Our Case Number: ACP-324447-26

Re: Proposed Upgrades to the Mortarstown Wastewater Treatment Plant and Kilkenny Road Pumping Station
Carlow, County Carlow

SID Online Observation

Online Reference
SID-OBS-006092

OVERVIEW PROPOSED SITE LAYOUT PLAN

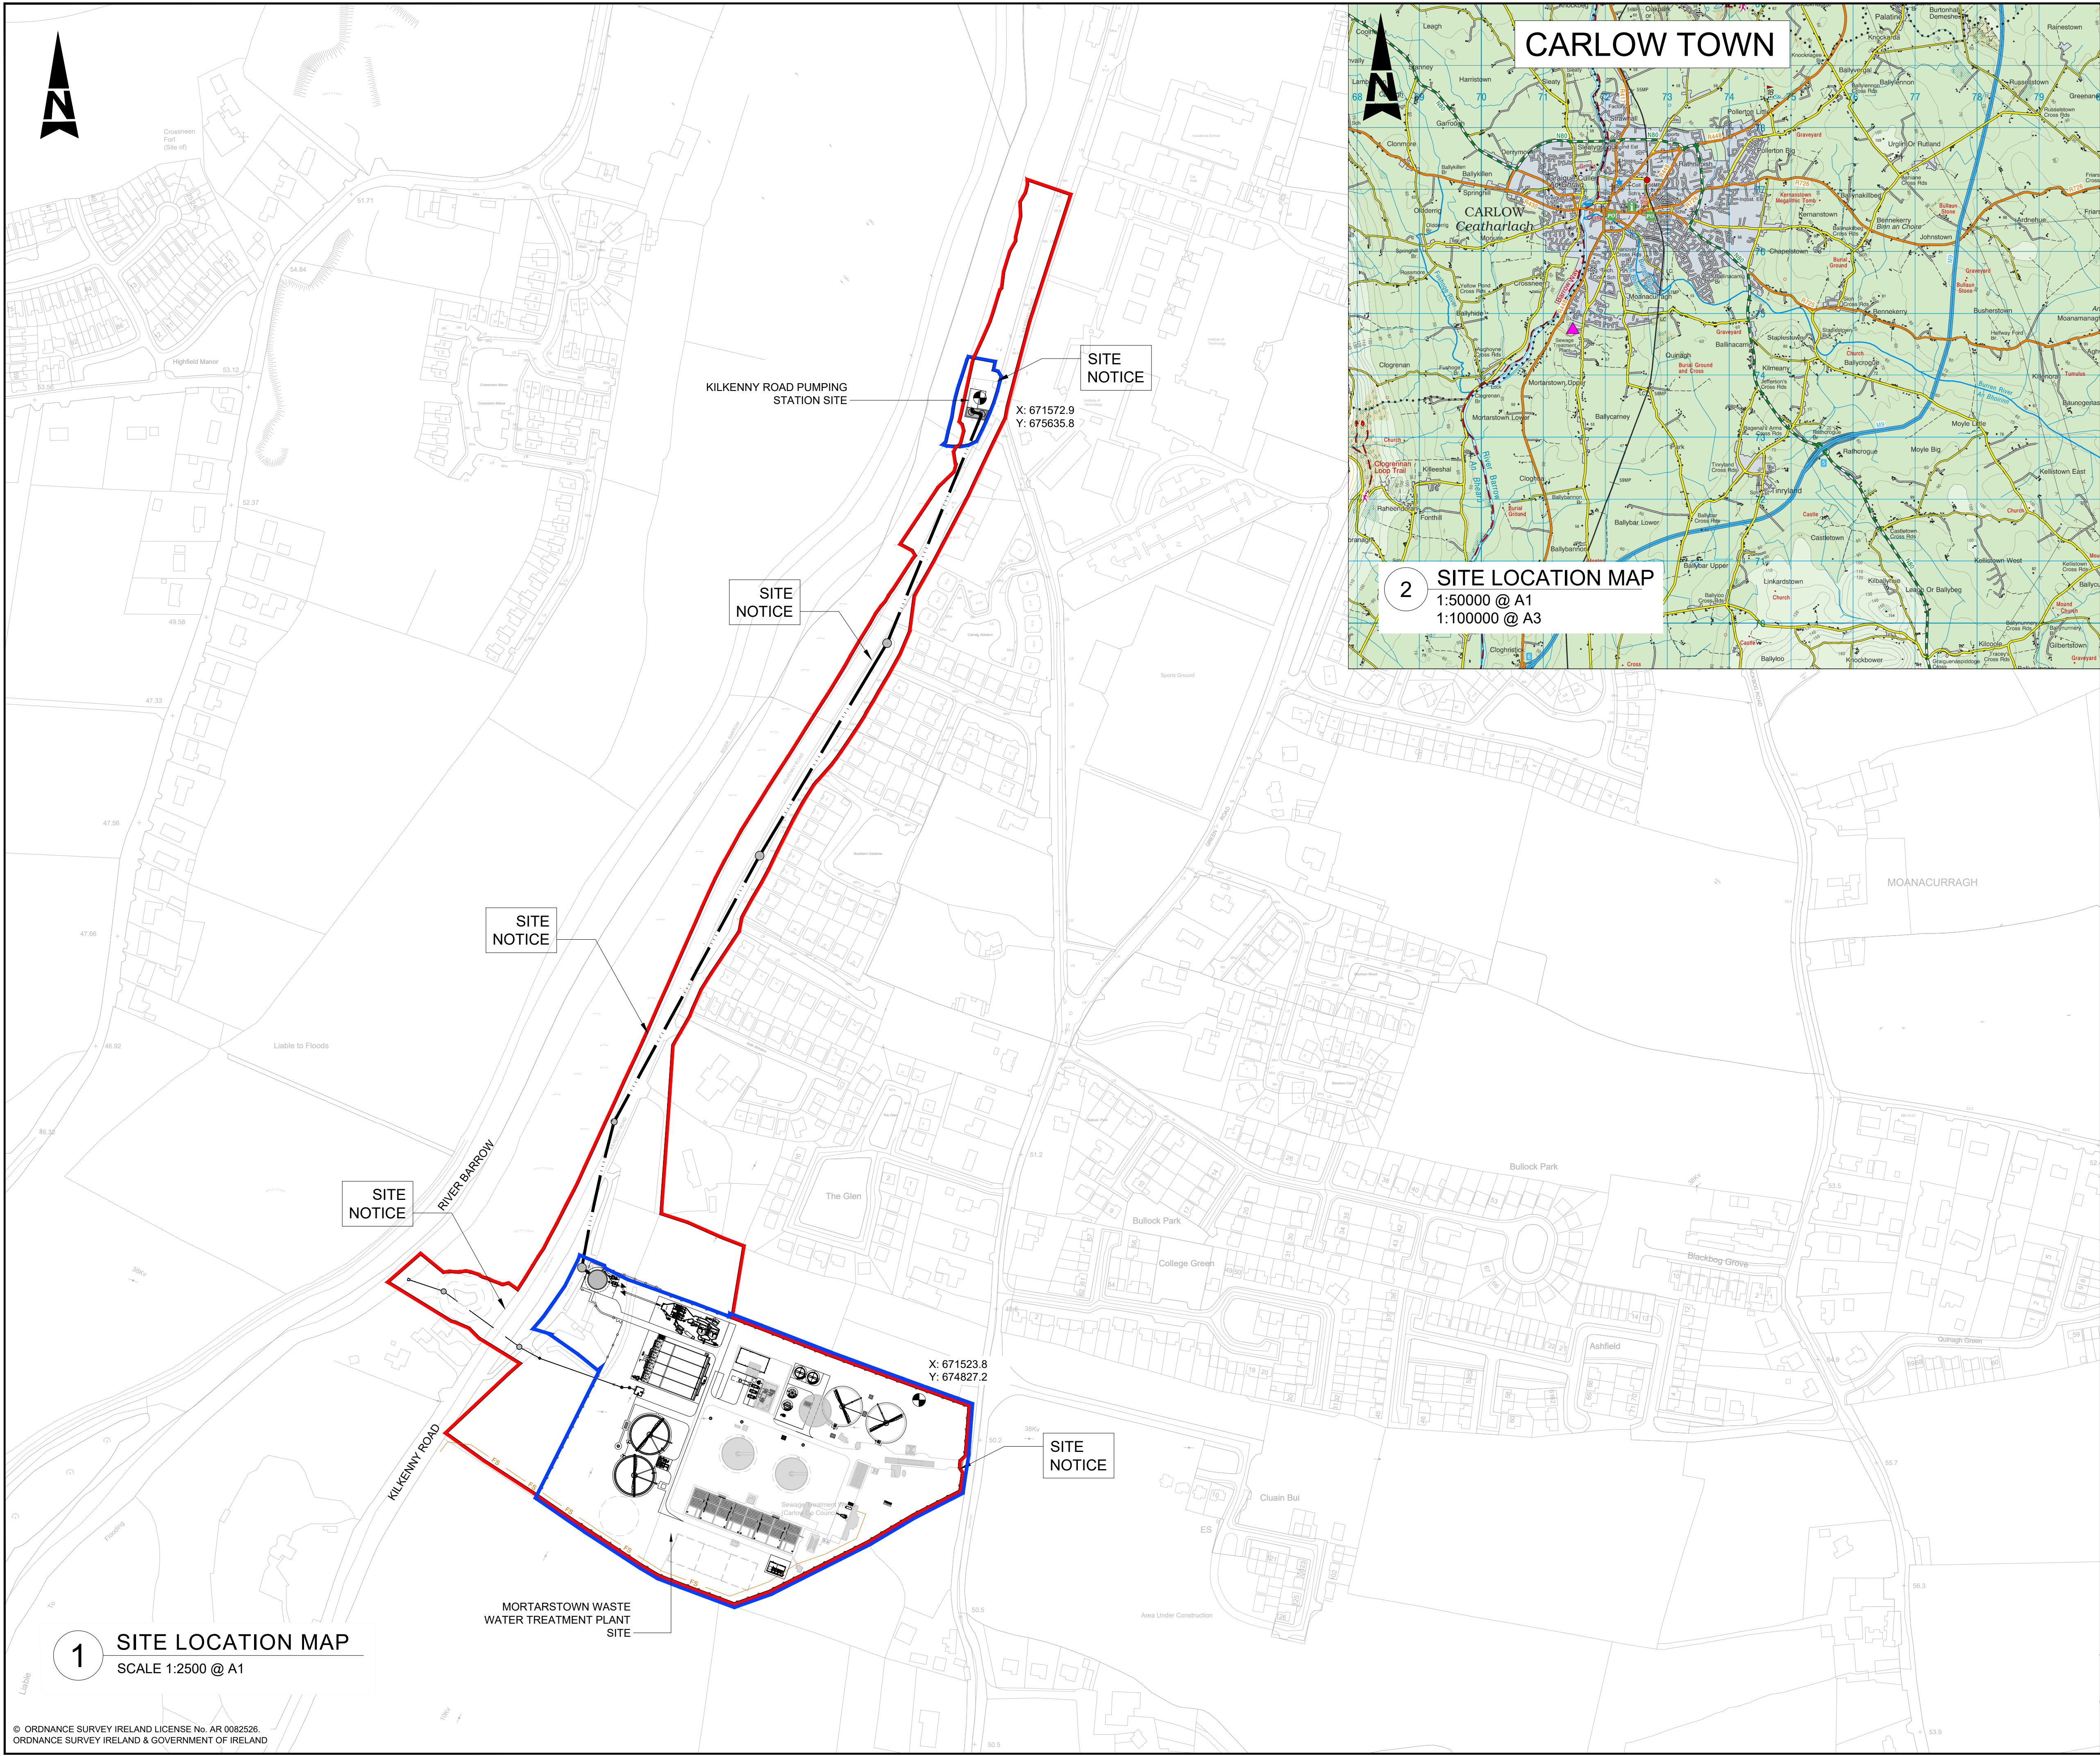
I have been a local resident in The Glen for 25 years. I have issue with the development's location on the site plan, especially the sludge handling area for the following reasons,

The existing sludge processing area is too close to the northeast fence; this is an issue as wind travels in this direction and the Glen residential estate area where I reside is approximately 60 meters from this fence downwind.

Environmental Impact Assessment Report (EIAR) volume 3, part 1 of 2, 7.1, 3, 3.1, Odour Management Plan, this states that consideration should be given to moving odour generating activities. These should be moved as far away from residential areas as possible. By leaving the sludge/ sewage import / export facility in the same location this has not been given consideration in the planning and needs to be moved to the other side of the plant site.
